Dear M/s Hughes,
Re: Mr and Mrs Stummer, Appn. 3/2002/0841.

Re: 3/2022/0841

Planning Application 3/2022/0841

Objection

DRAWING NAME
LOCATION PLAN

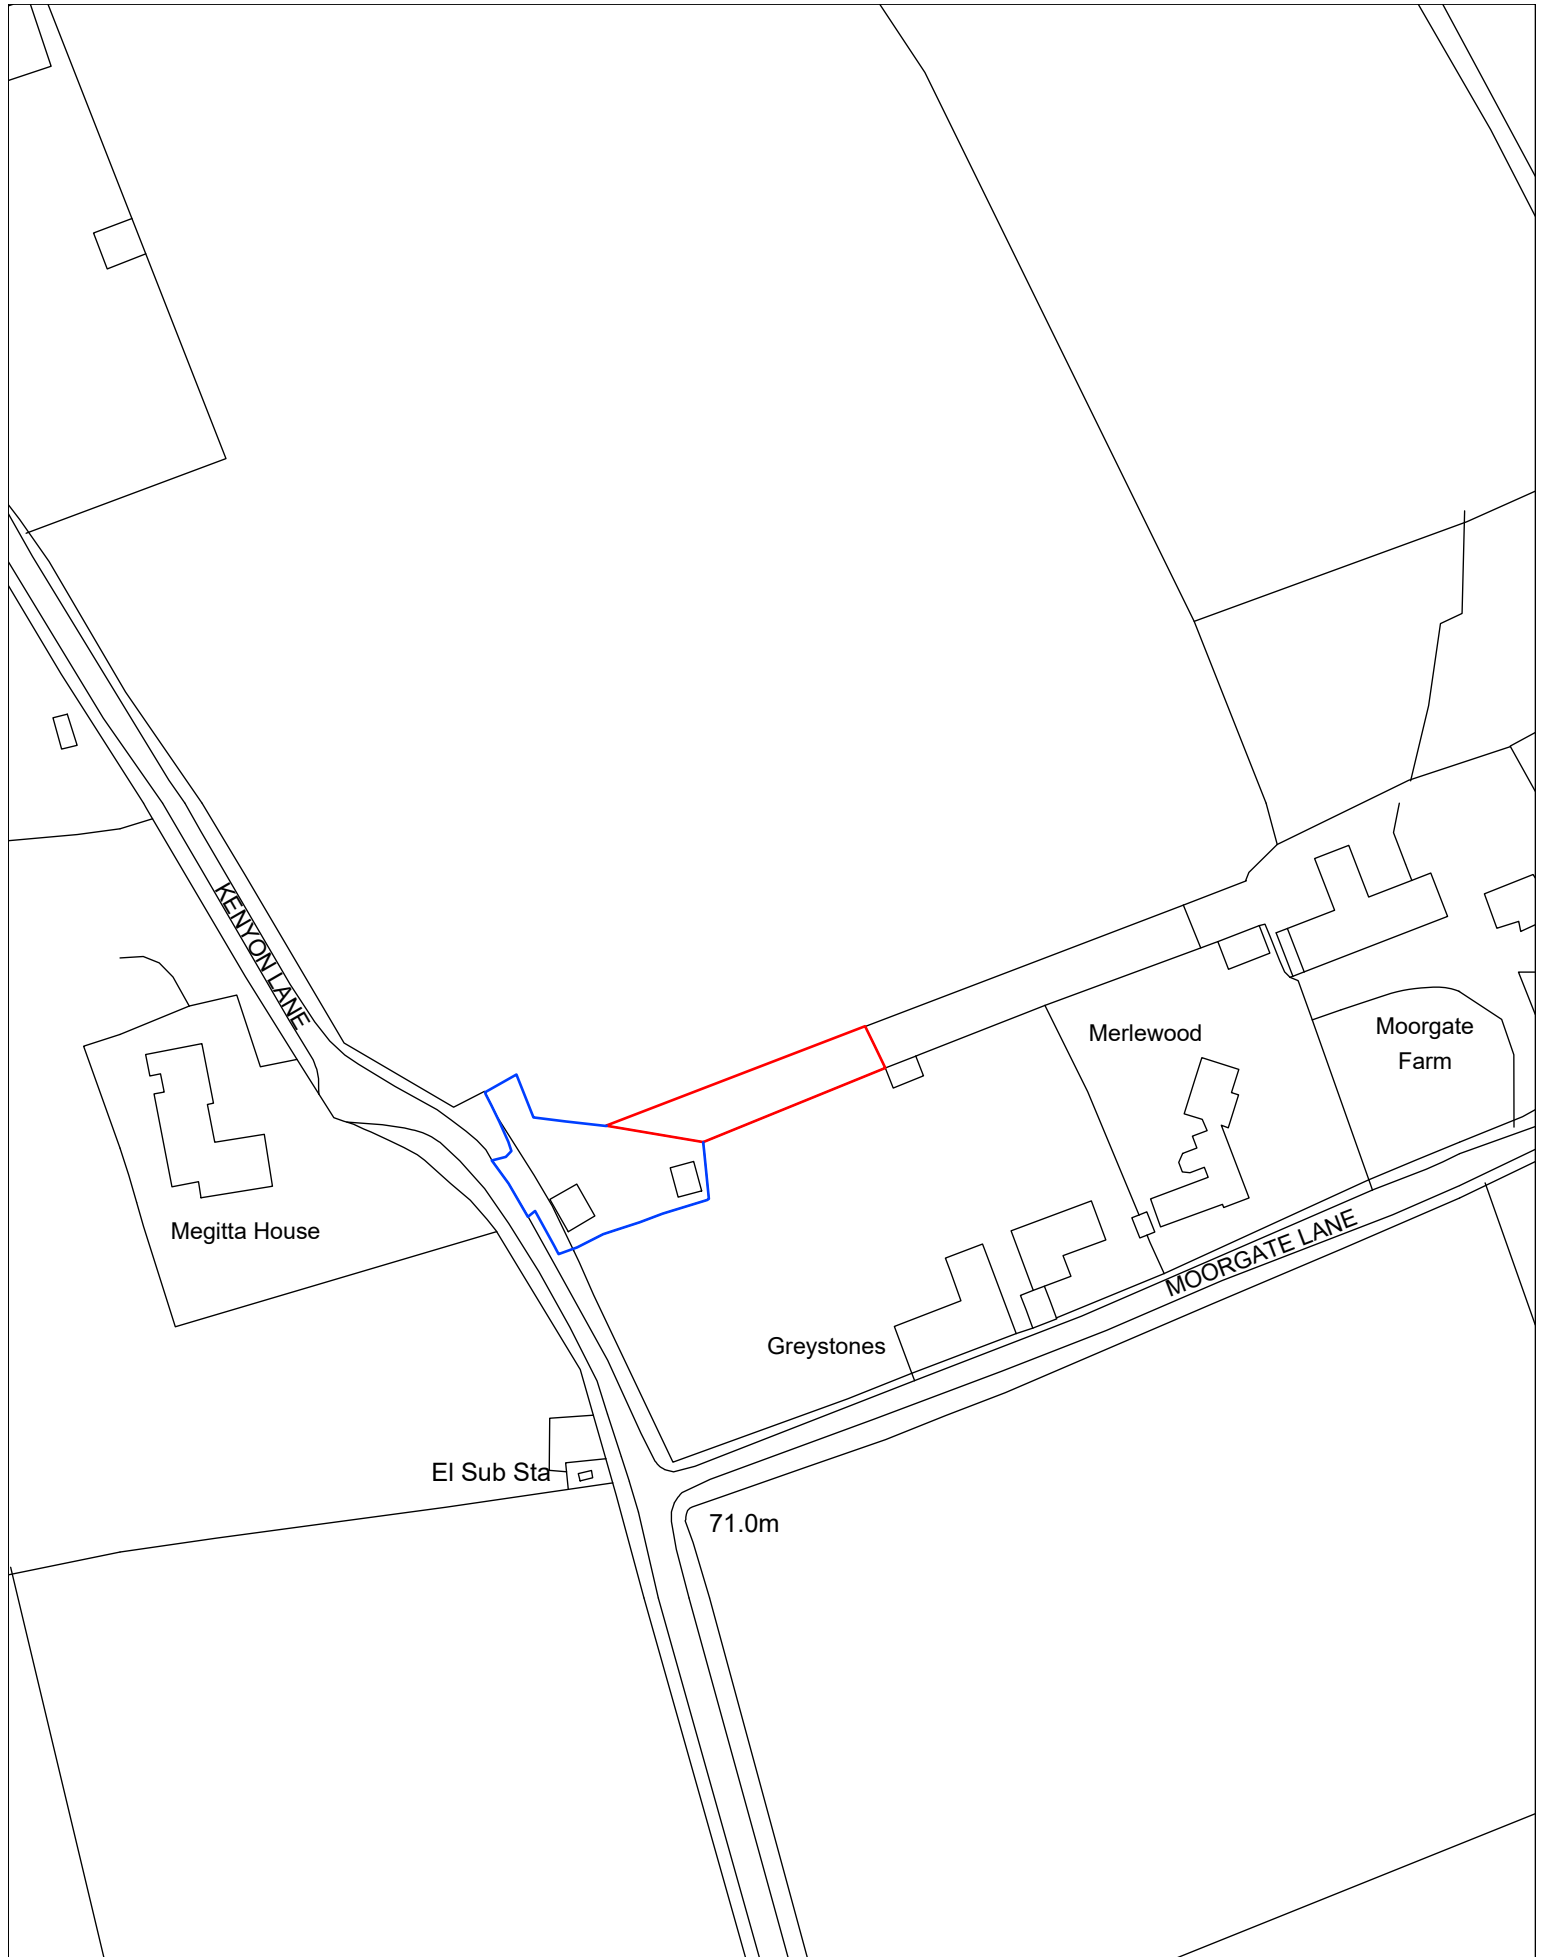
The "existing site plan" submitted with the application shows a plot of land to the rear of Greystones and incorrectly describes it as an allotment to that property. This area does not belong to Greystones.

Title: Site Plan & Viewpoints

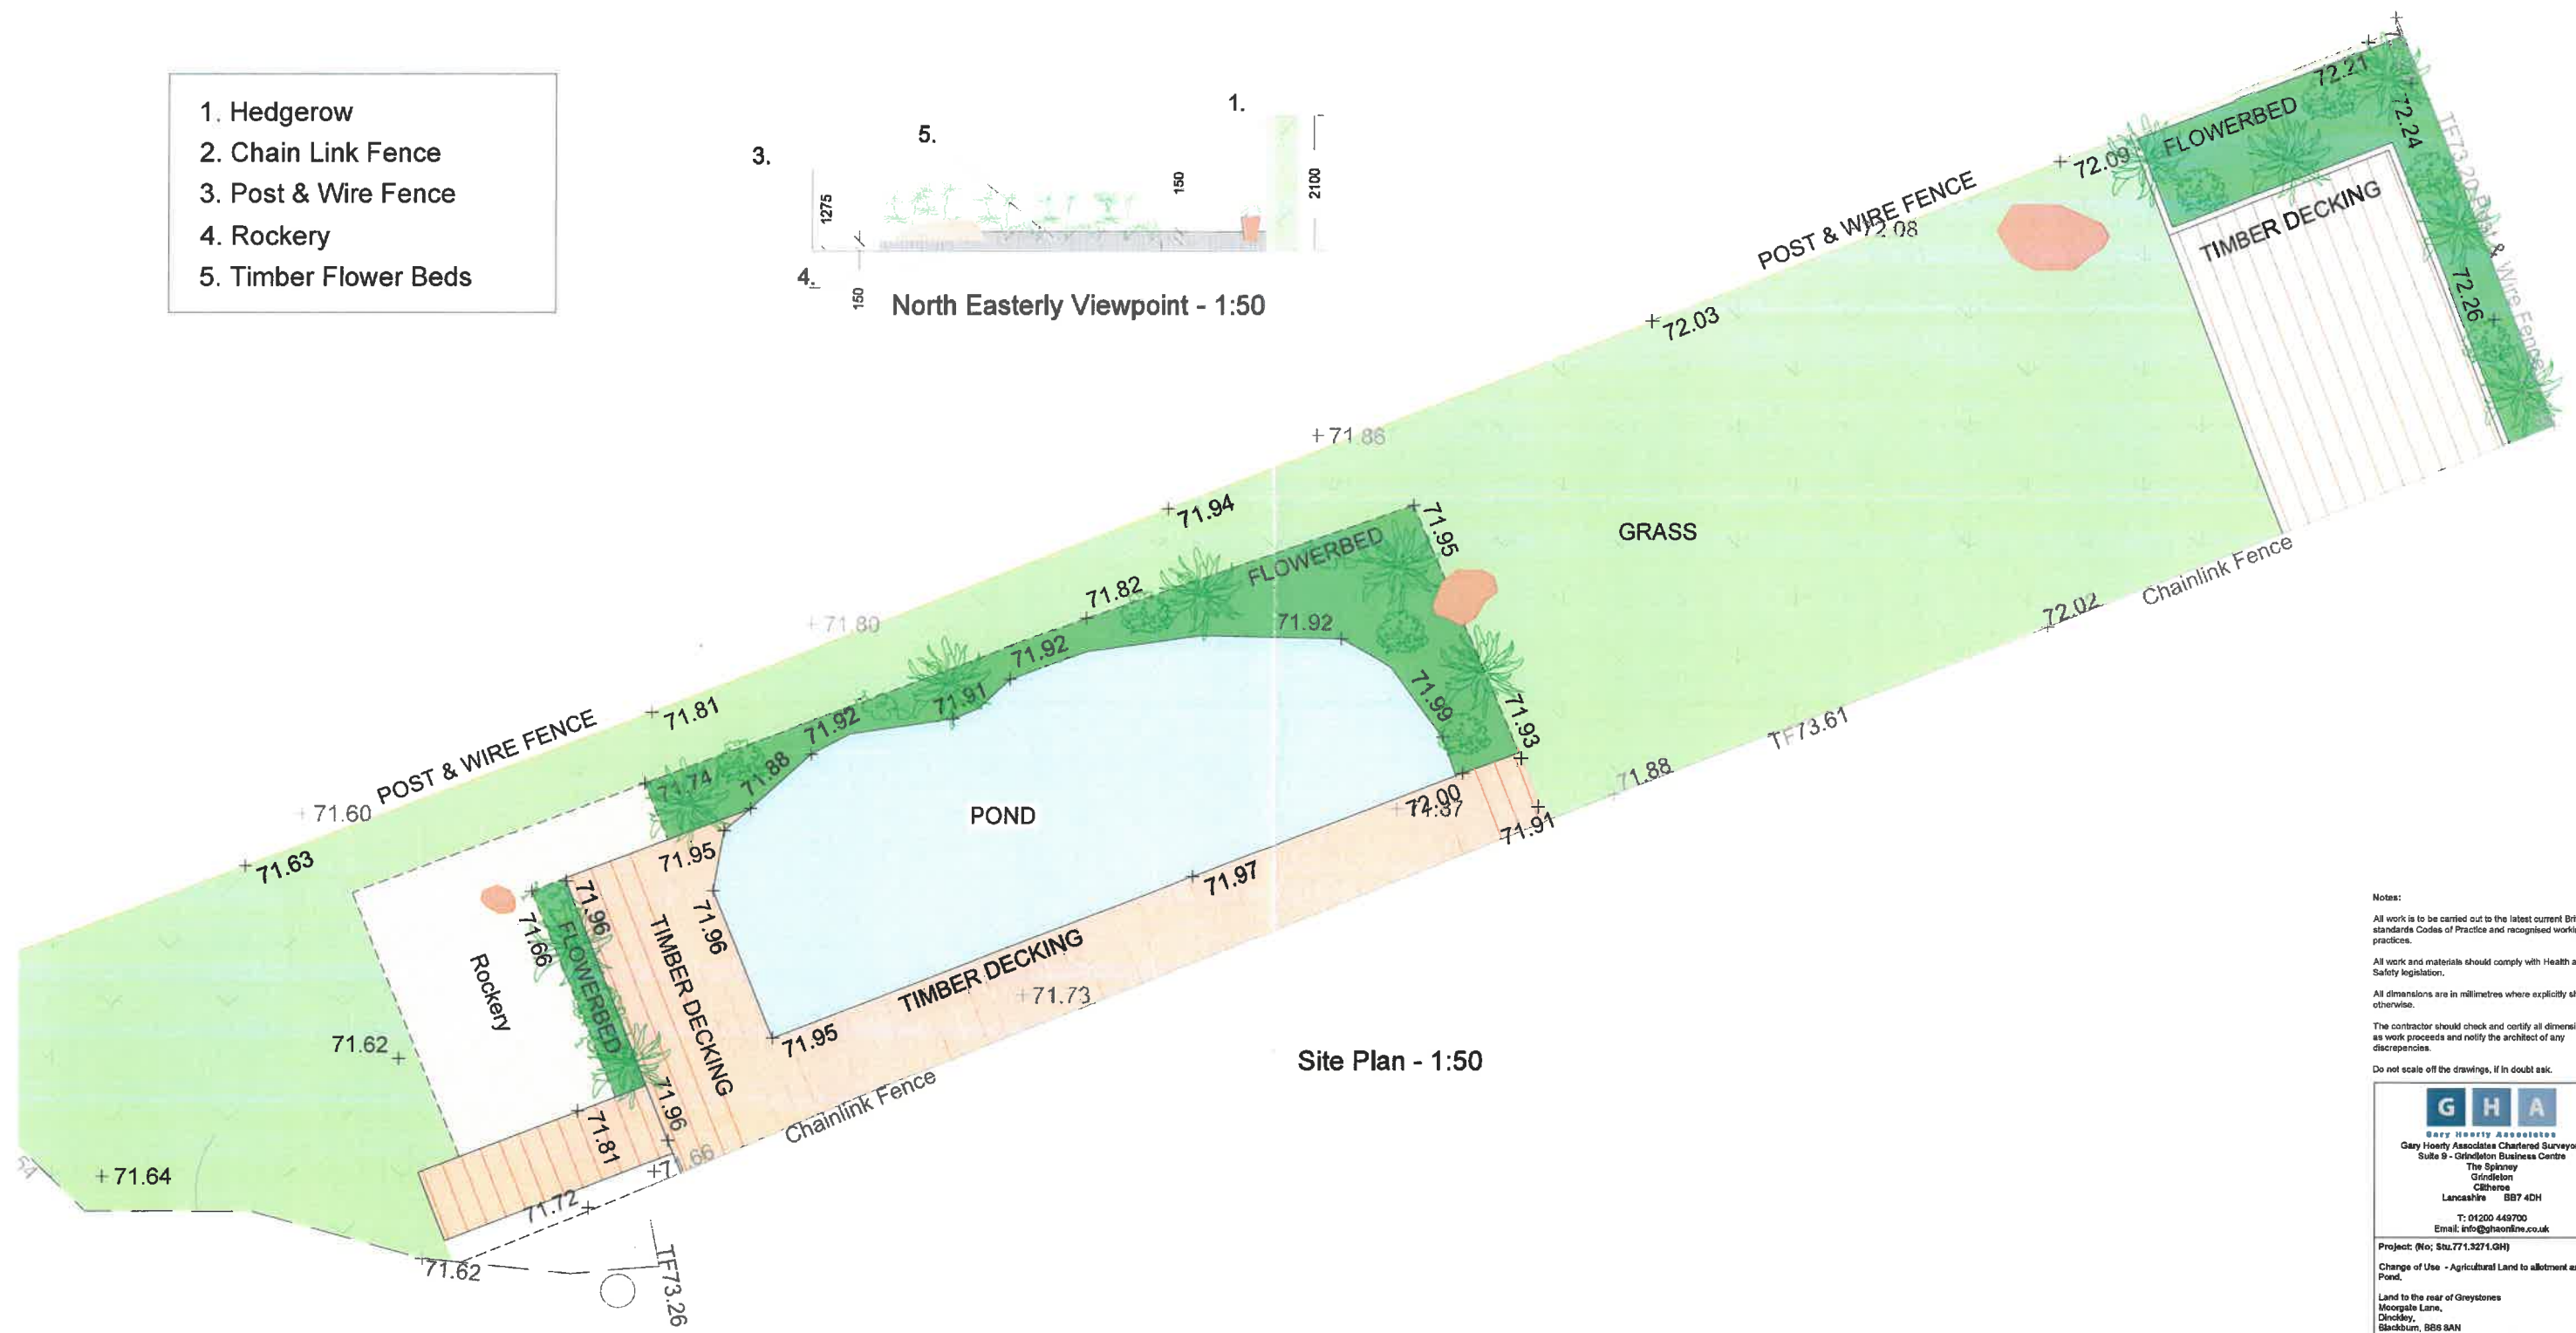
The "site plan and view points" submitted with the application demonstrates that it is currently impossible for the site to be described and used as an allotment as approximately two thirds comprise a pond, (which constitutes unauthorised groundwork) decking, a rockery and mature shrub/flower beds. All this results in a formally laid out ornamental, residential garden which has been constructed, without permission, purely for leisure purposes on a plot of land that was originally agricultural meadow land in contravention of the planning rules and policies and constitutes urbanisation of the countryside. This plot immediately abuts two long standing, substantial, detached country properties and is an invasion of their privacy.

In the application form the applicants say that disposal of foul sewage and any existing drainage system is "unknown." This is misleading because this site with decking and a pond will need drainage and the owners must be aware of any pipes and tanks they have laid under their plots and their location and these should be identified on their plans.
